Mary-Jane Betts  
Cowridge 473 Black Range Road  
YASS NSW 2582

07 October 2023

**SUBMISSION IN RESPONSE TO THE ENVIRONMENTAL IMPACT STATEMENT OF THE  
HUMELINK PROJECT - SSI-36656827**

Figure 4a map reference 69

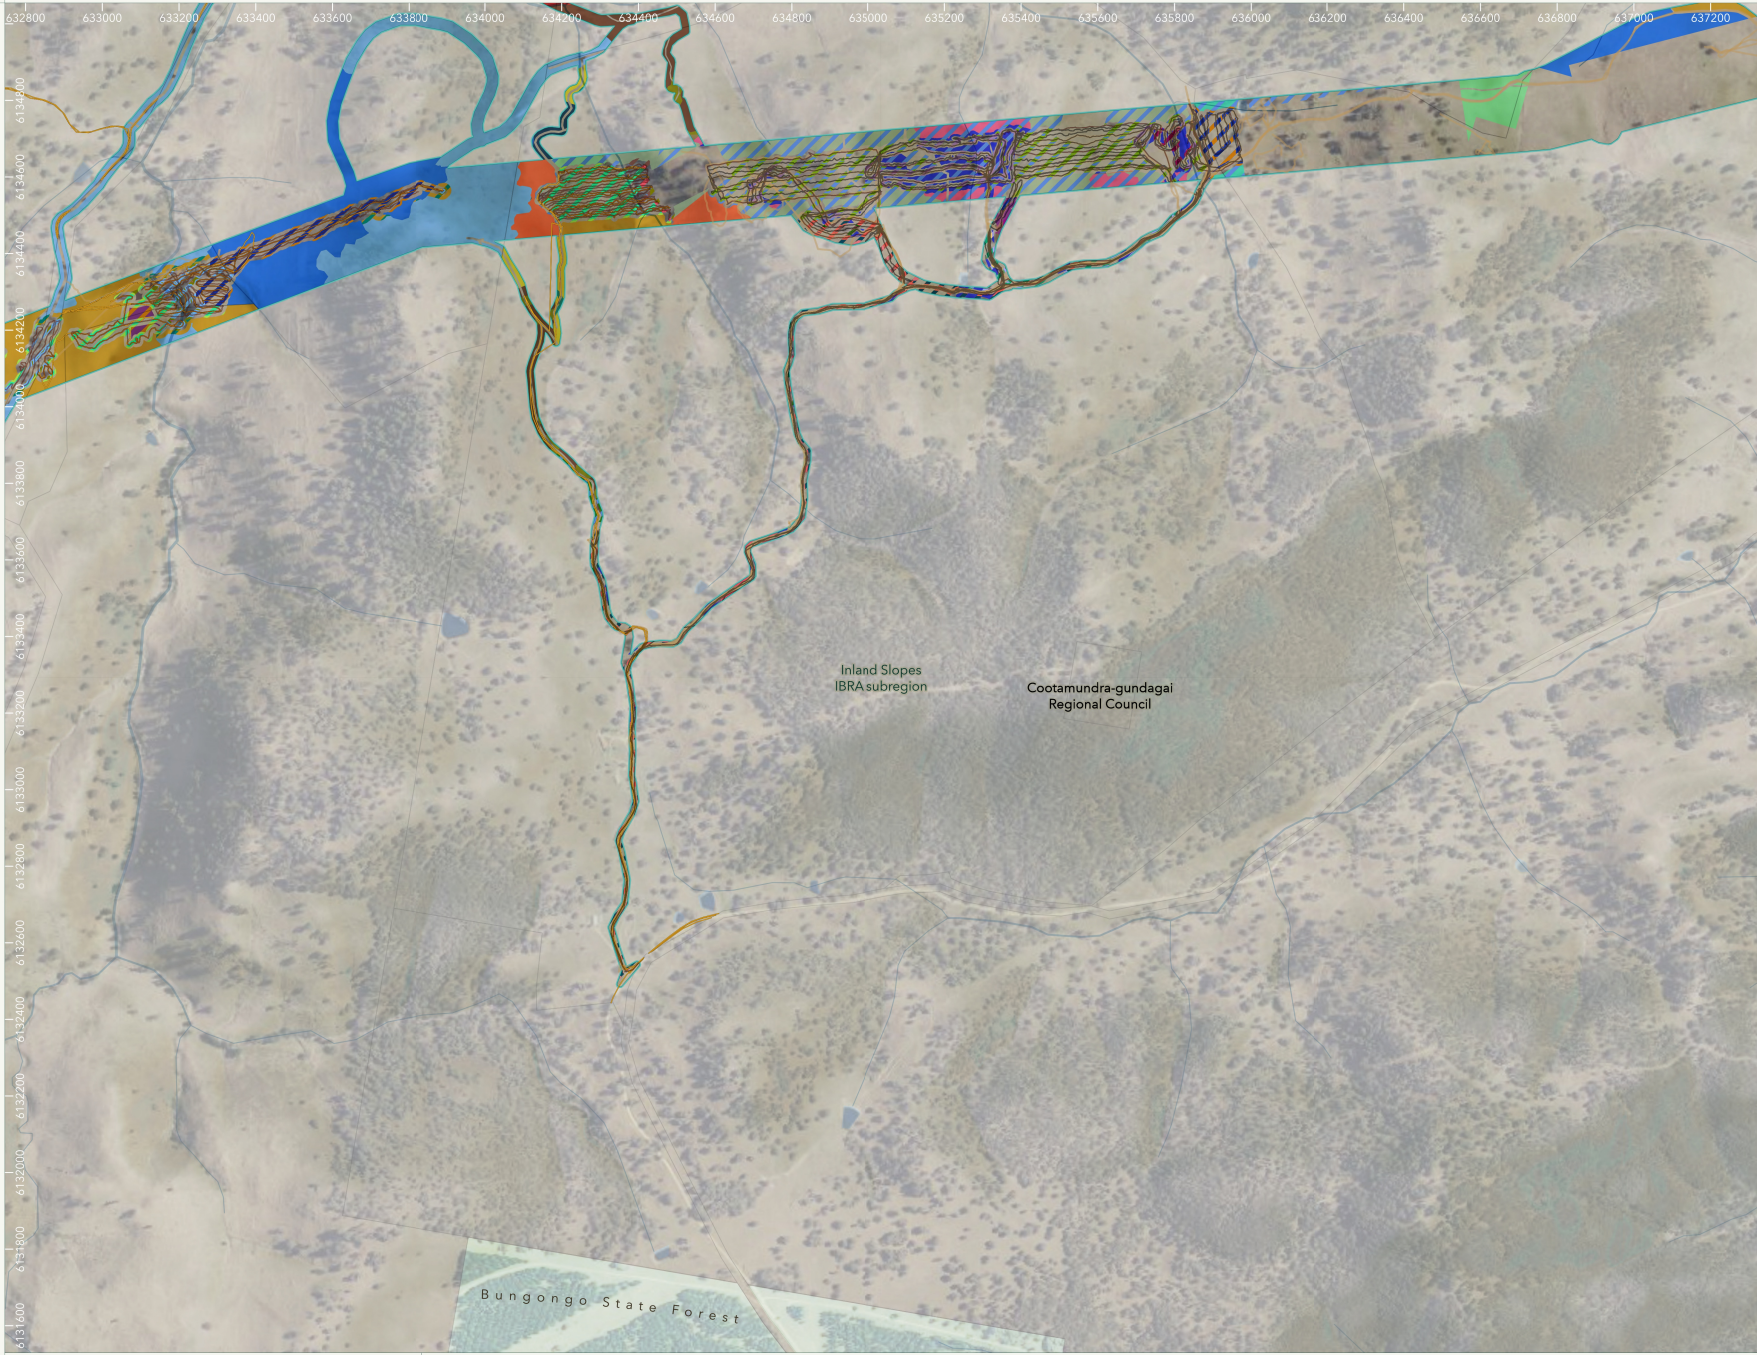
My property is *identified in the Ecology Assessment in the EIS in (EIS REF: DBAR Part 2 Figures 1 of 3 Figure 7-2 Map ref 68,69,70 –pages 564-566 of 599)*

- **The EIS ecology surveys undertaken by Transgrid are NOT comprehensive.** Relevant biodiversity assessment has been omitted.
- **The Derringullen falls is not mentioned,** the waterfall is central in the surveyed corridor. Reading the EIS surveyed documents you would not know this landmark feature exists.

- The vulnerable Little Eagle has been recorded in the ecology survey but the protected Wedge-Tailed Eagle pair and nesting tree within the 70m easement were not marked on survey maps. It is a certainty, death by electrocution, and will never return to this habitat and hunting grounds. All raptor birdlife connectivity to waterways and landscape are now threatened survival.

- **Transgrid have contradicted themselves in the EIS; stating Transgrid will choose the narrowest waterway crossing point. With the lowest impact.** This is definitely the opposite case in point. Transgrid have decided to cross the Derringullen Creek, over the widest point a very large span, over a landmark Derringullen Falls, (although, incredibly, this is not mentioned in the EIS), cutting through conservation land that has had funded project money to fence off the waterway and re-vegetate over a long-term projected time. **The total clearing zone indicated in map 69 (reference above) and the span over the waterway is ridiculous and simply does not make sense.**
